Planning Application No: 2026/62/91926/E

Address: 158 Hawthorne Way Shelley

Description: Change of use of garage to treatment room for hairdressing including installation of bi-fold doors to existing opening

PROPOSED MATERIALS	
• DOORS	— ALUMINIUM BI-FOLDS

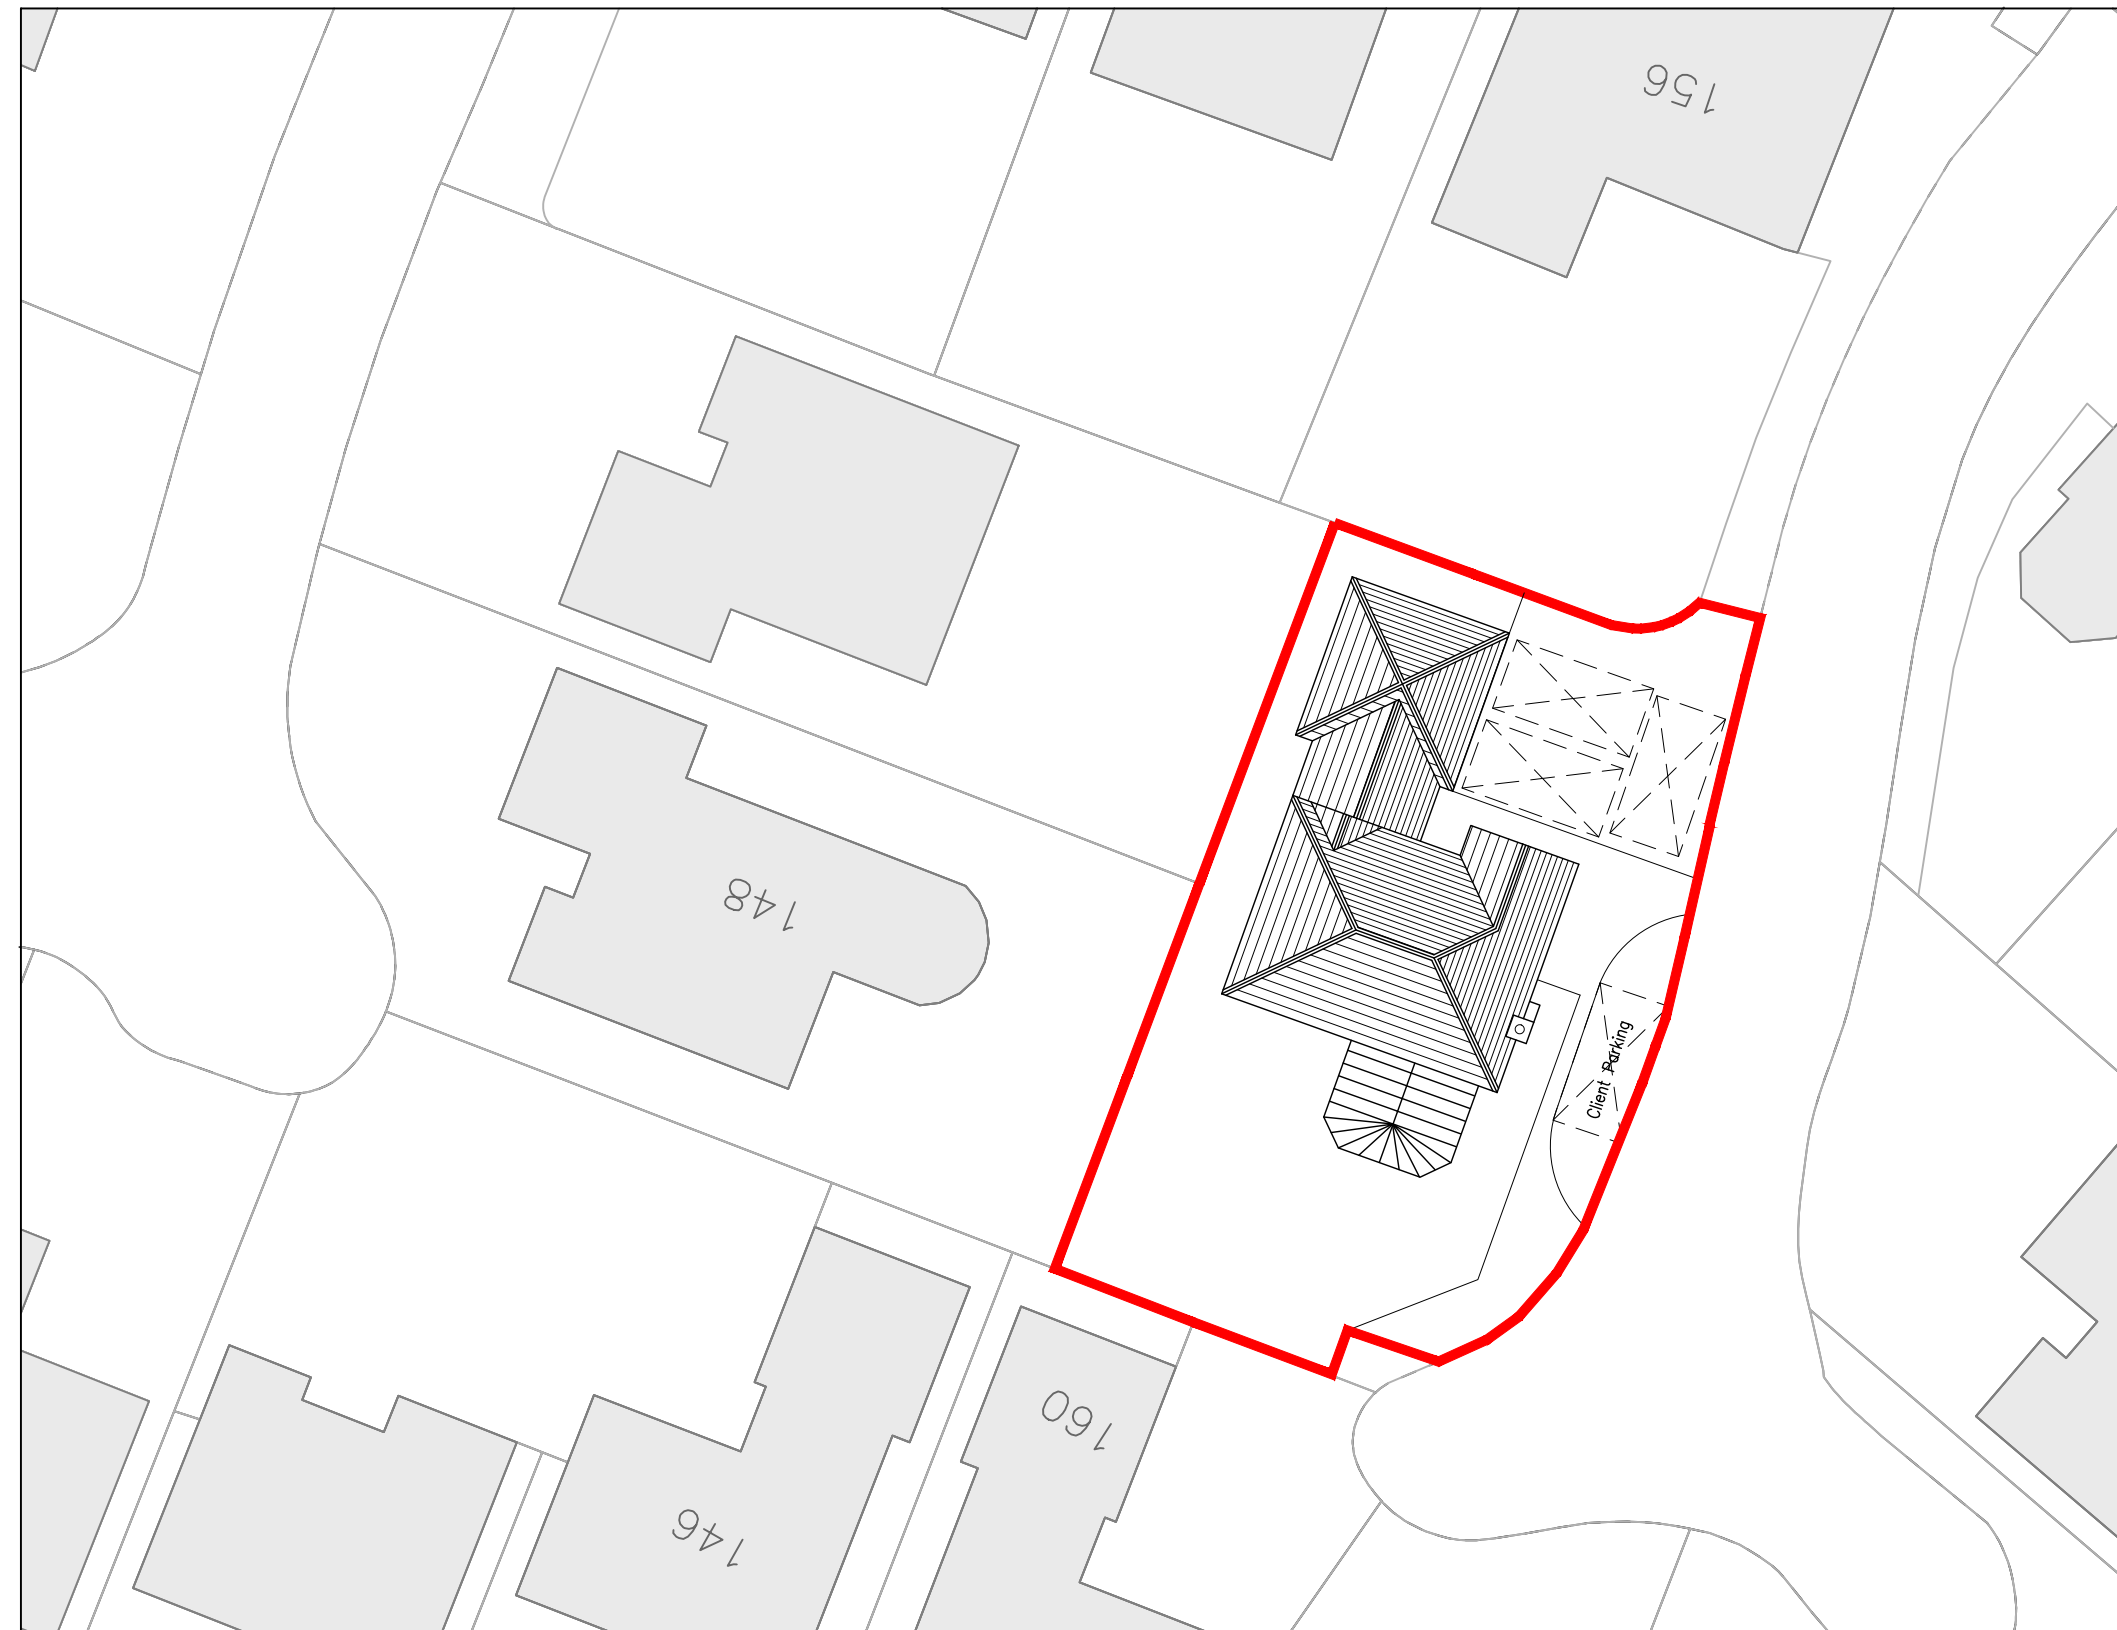
The amended 383-26-PL02 Rev B submitted 14.9.26 shows three parking spaces which can now be accessed independently of one another, a preferred requirement of DC highways officers in my experience. The three spaces are the minimum required for any garage conversion due to the loss of 2 spaces from within the garage, regardless of its use.

However, the application as amended now doesn't provide the 4th off-street parking for customers, due to the proposed business use. Given our previous comments which clearly show that 75% of the time there are always 2 customers at the property at any one time surely the application should provide for two additional spaces. As this cannot be provided the application should be refused on highways grounds.

In order for the three spaces to be provided as shown, the existing drive will need to be extended again. The drawings don't indicate how this will be done nor has it been added to the description. Unless drainage is to be provided planning permission would also be required for this, however given the sloping nature of the drive appropriate drainage would be difficult to achieve.

The amended plans showing the bi-fold inwards does reduce the obstruction on the drive for parking, but doesn't overcome our previous concerns with regards: -
